**Byers Gill Solar  
EN010139**

# 3.3 DCO Schedule of Changes

Deadline 2 – August 2024

Drawing Title  
**Street Works, Public Rights of Way & Access Plans**  
Sheet 11 of 13  
**APFP Regulation 5(2)(k)**

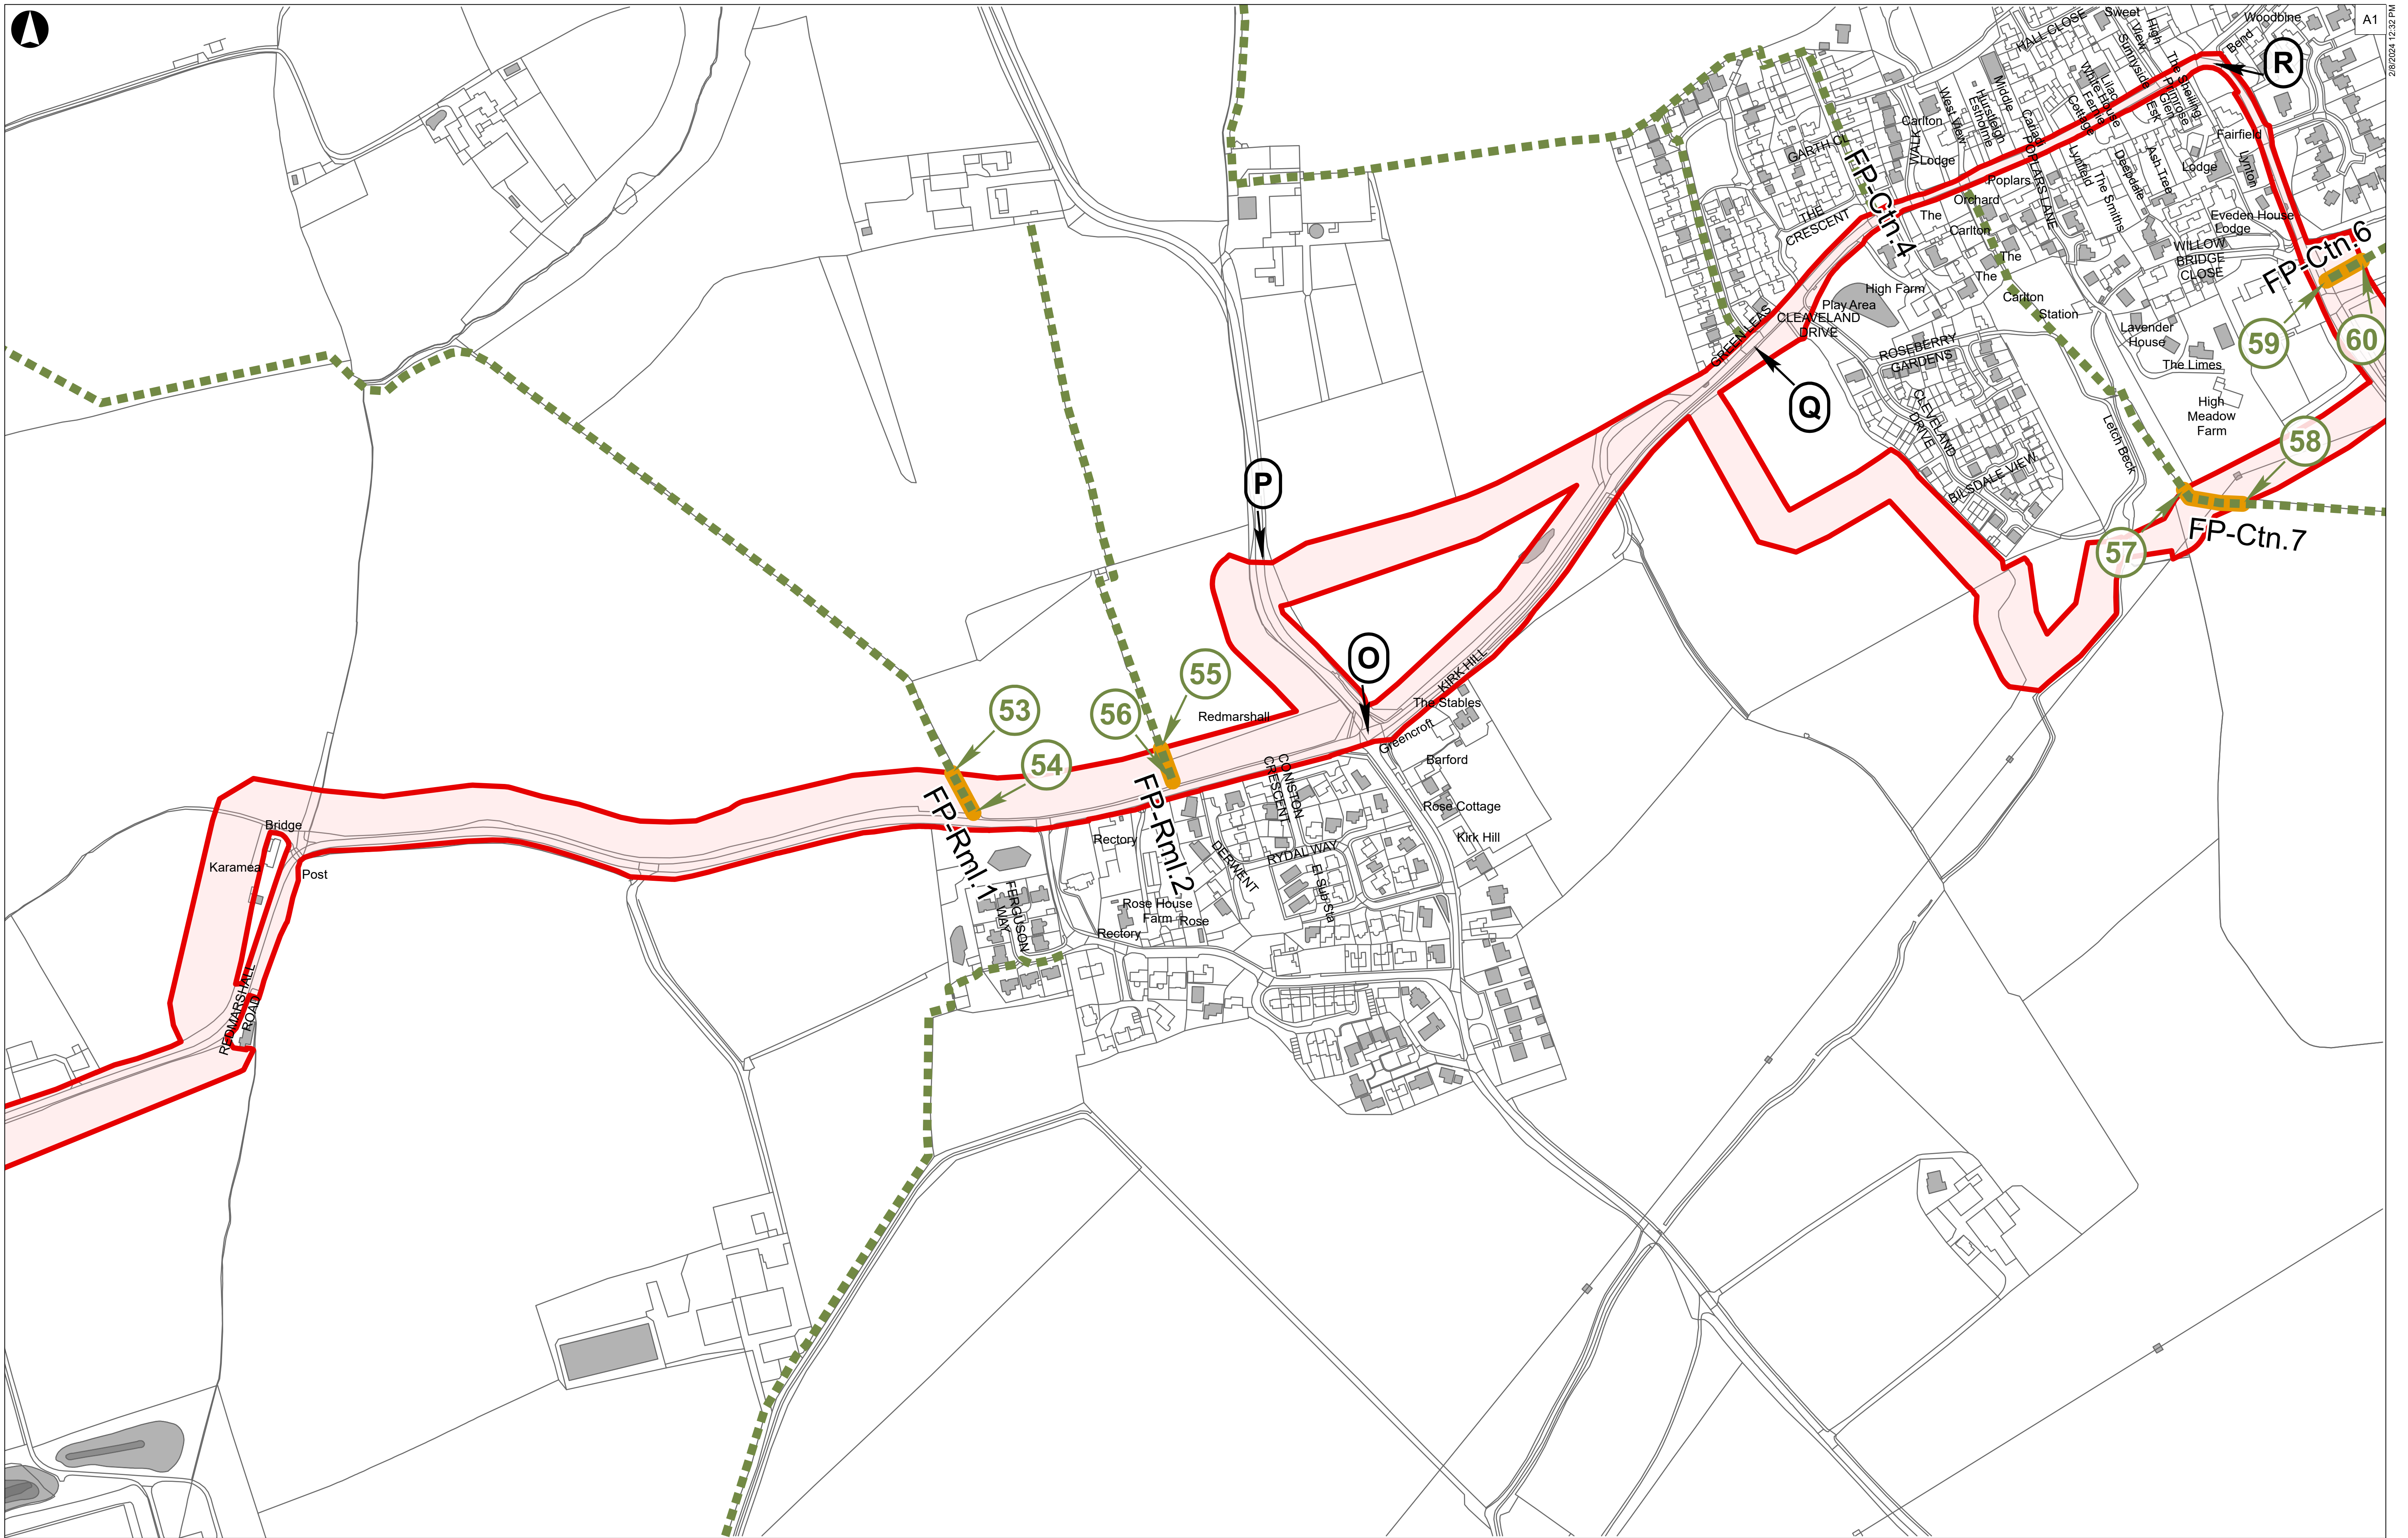
<u><i>Parish of Bishopton</i></u>	<u><i>Folly Bank</i></u>	<u><i>Cable works beneath the width of street as shown with reference CC5 on sheet 9 of the street works, public rights of way and access plans.</i></u>
<u><i>Parish of Redmarshall</i></u>	<u><i>Redmarshall Road, in the vicinity of Morington Bridge</i></u>	<u><i>Cable works beneath the width of street as shown with reference CC6 on sheet 11 of the street works, public rights of way and access plans.</i></u>

These two rows have been added to provide street works descriptions for two locations where the Applicant proposes to carry out cabling works across the width of a street for the purpose of delivering the off-road cable route. These descriptions are included as a correction to Revision 1 of the dDCO.

<p>The following rows have been removed from the table of street works in Schedule 3:</p> <table border="1" data-bbox="577 373 1263 1029"> <tr> <td data-bbox="577 373 779 703"> <p><del>Parish of Bishopton</del></p> </td> <td data-bbox="779 373 891 703"> <p><del>The Green</del></p> </td> <td data-bbox="891 373 1263 703"> <p><del>Cable works beneath the width of highway comprising a length of 330m as shown between points marked K and M on sheets 9 and 11 of the street works, public rights of way and access plans.</del></p> </td> </tr> <tr> <td data-bbox="577 703 779 1029"> <p><del>Parish of Bishopton</del></p> </td> <td data-bbox="779 703 891 1029"> <p><del>High Street</del></p> </td> <td data-bbox="891 703 1263 1029"> <p><del>Cable works beneath the width of highway comprising a length of 700m as shown between points marked M and N on sheets 9 and 11 of the street works, public rights of way and access plans.</del></p> </td> </tr> </table>	<p><del>Parish of Bishopton</del></p>	<p><del>The Green</del></p>	<p><del>Cable works beneath the width of highway comprising a length of 330m as shown between points marked K and M on sheets 9 and 11 of the street works, public rights of way and access plans.</del></p>	<p><del>Parish of Bishopton</del></p>	<p><del>High Street</del></p>	<p><del>Cable works beneath the width of highway comprising a length of 700m as shown between points marked M and N on sheets 9 and 11 of the street works, public rights of way and access plans.</del></p>	<p>These two rows were previously included to provide street works descriptions for the cabling works proposed to be carried out for the on-road cable route through Bishopton.</p> <p>These two have been removed because the cable route optionality in this location has been resolved in favour of the off-road route to the south of Bishopton Village and the Order limits have been updated to remove the on-road cable route through Bishopton. See the Applicant’s Notification of Intention to Submit New or Revised Information – Accepted at the discretion of the Examining Authority [AS-010] for further details.</p>
<p><del>Parish of Bishopton</del></p>	<p><del>The Green</del></p>	<p><del>Cable works beneath the width of highway comprising a length of 330m as shown between points marked K and M on sheets 9 and 11 of the street works, public rights of way and access plans.</del></p>						
<p><del>Parish of Bishopton</del></p>	<p><del>High Street</del></p>	<p><del>Cable works beneath the width of highway comprising a length of 700m as shown between points marked M and N on sheets 9 and 11 of the street works, public rights of way and access plans.</del></p>						
<p><b>Schedule 11, Part 4 (For the Protection of the Environment Agency)</b></p>	<p>Part 4 (For the Protection of the Environment Agency) has been removed from Schedule 11.</p>	<p>Following engagement with the Environment Agency, Part 4 of Schedule 11 has been removed as a responsive amendment to the removal of Article 7(1)(b) above. The parties agree that the Protective Provisions previously included at Part 4 of Schedule 11 are redundant.</p>

Corresponding amendments have been made to the Street Works, Public Rights of Way and Access Plans to indicate these locations.
